75-85 Harrington Street Mixed Use Mod 3 (SSD 7037 Mod 3)
Request for Additional Information

Additional comment from Roads and Maritime Services within Transport for New South Wales

PROPOSED PUBLIC PEDESTRIAN RAMP

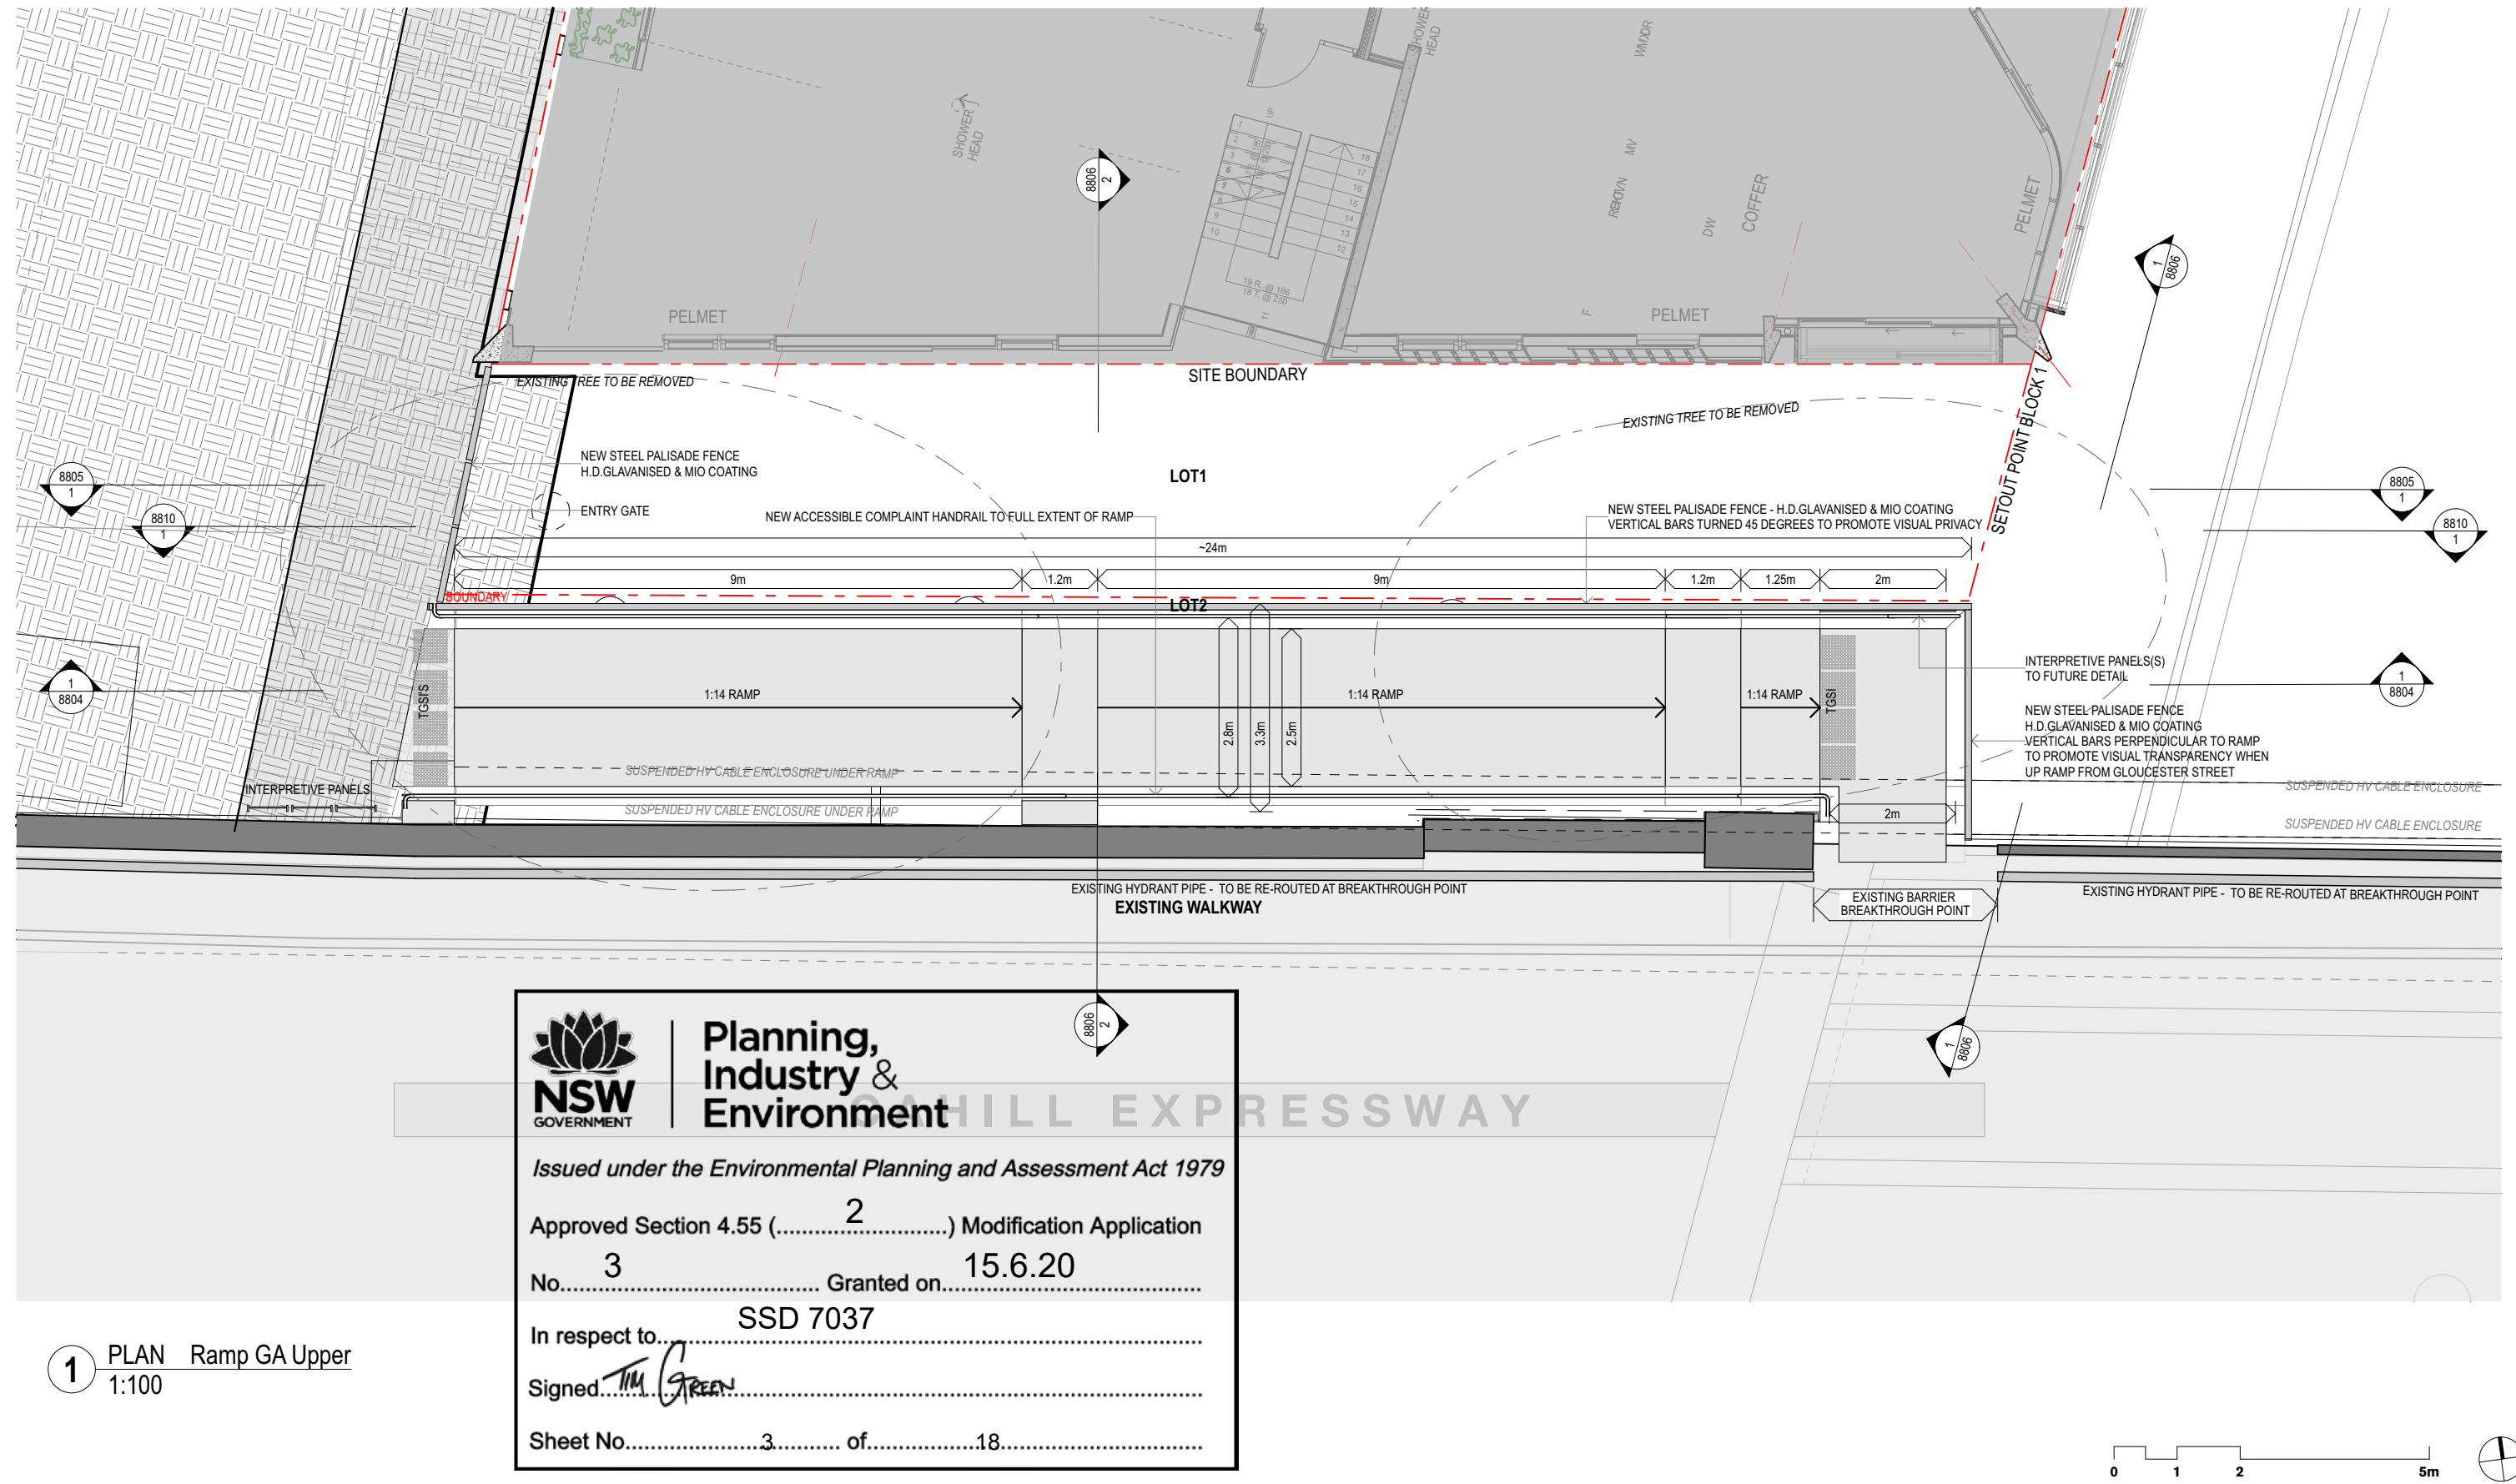
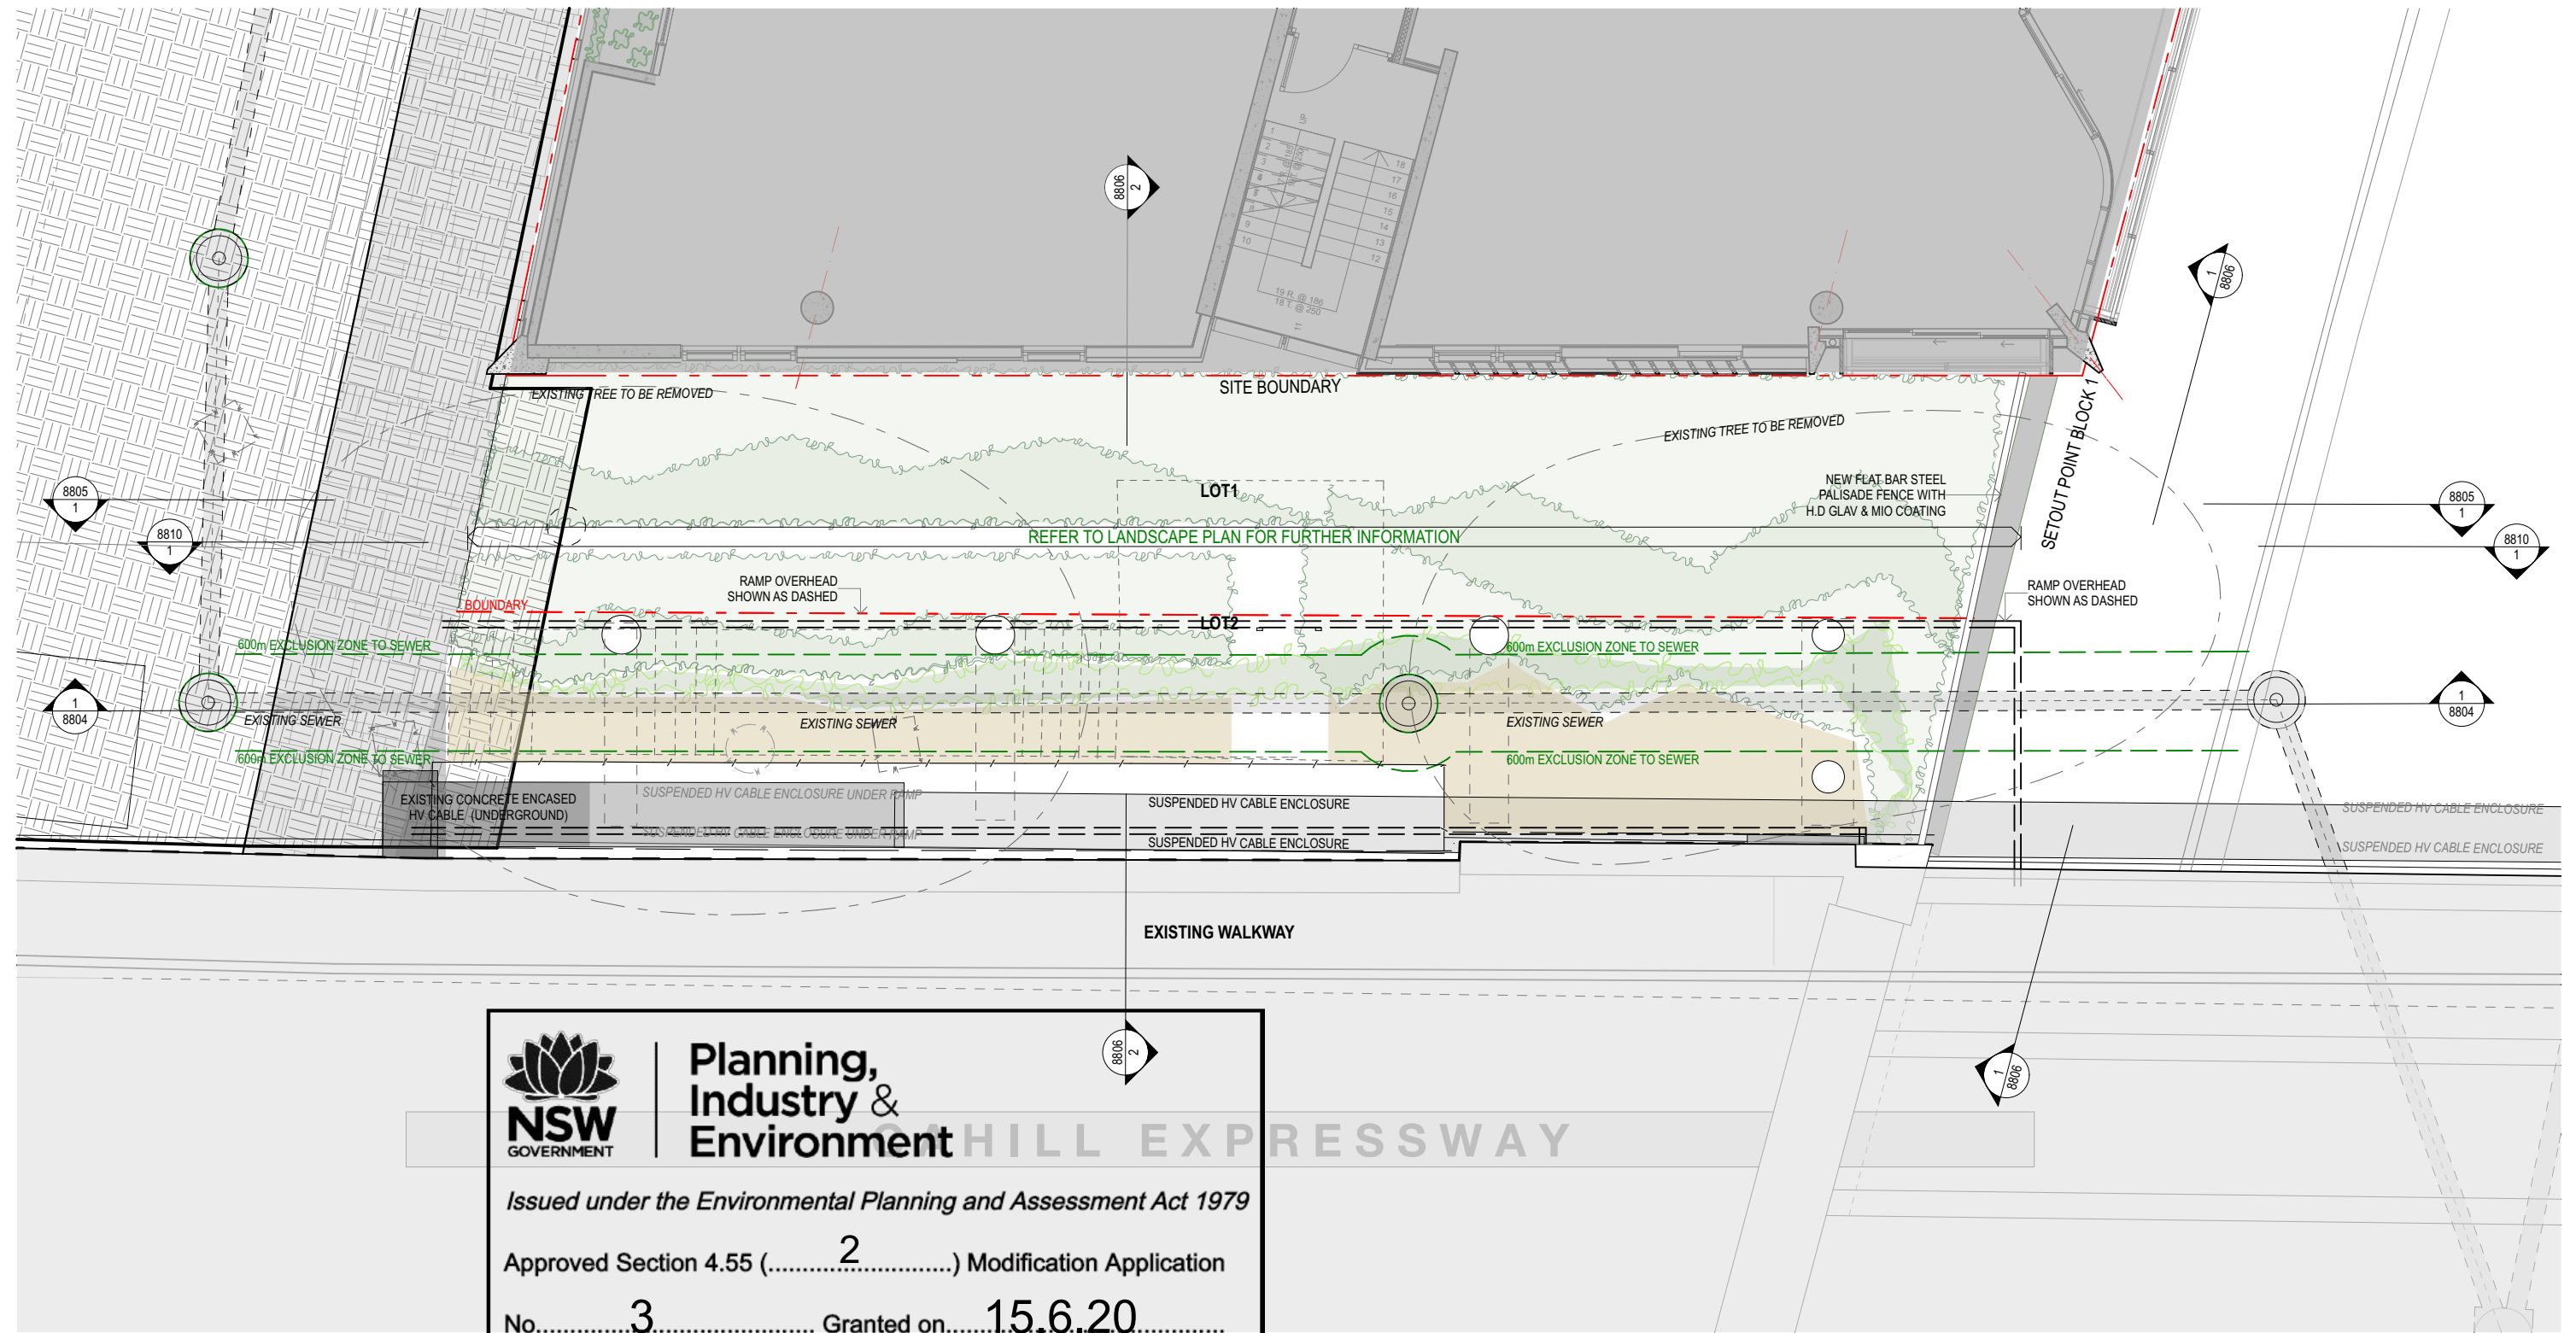
TfNSW has re-reviewed the related information relating to the shared use of the proposed ramp for both pedestrian and cycling.

Ultimately, TfNSW has no objections for the proposed shared use of the ramp. However TfNSW does reiterate and support comments and recommendations from the Access Report prepared by Morris Goding Access Consulting. Whilst the minimum shared path width of 2.5m as per Austroads is being met, it may not be wide enough to cope with pedestrian volumes that are likely to use the ramp and as such should include design measures to reduce any potential conflict between cyclists and pedestrians.
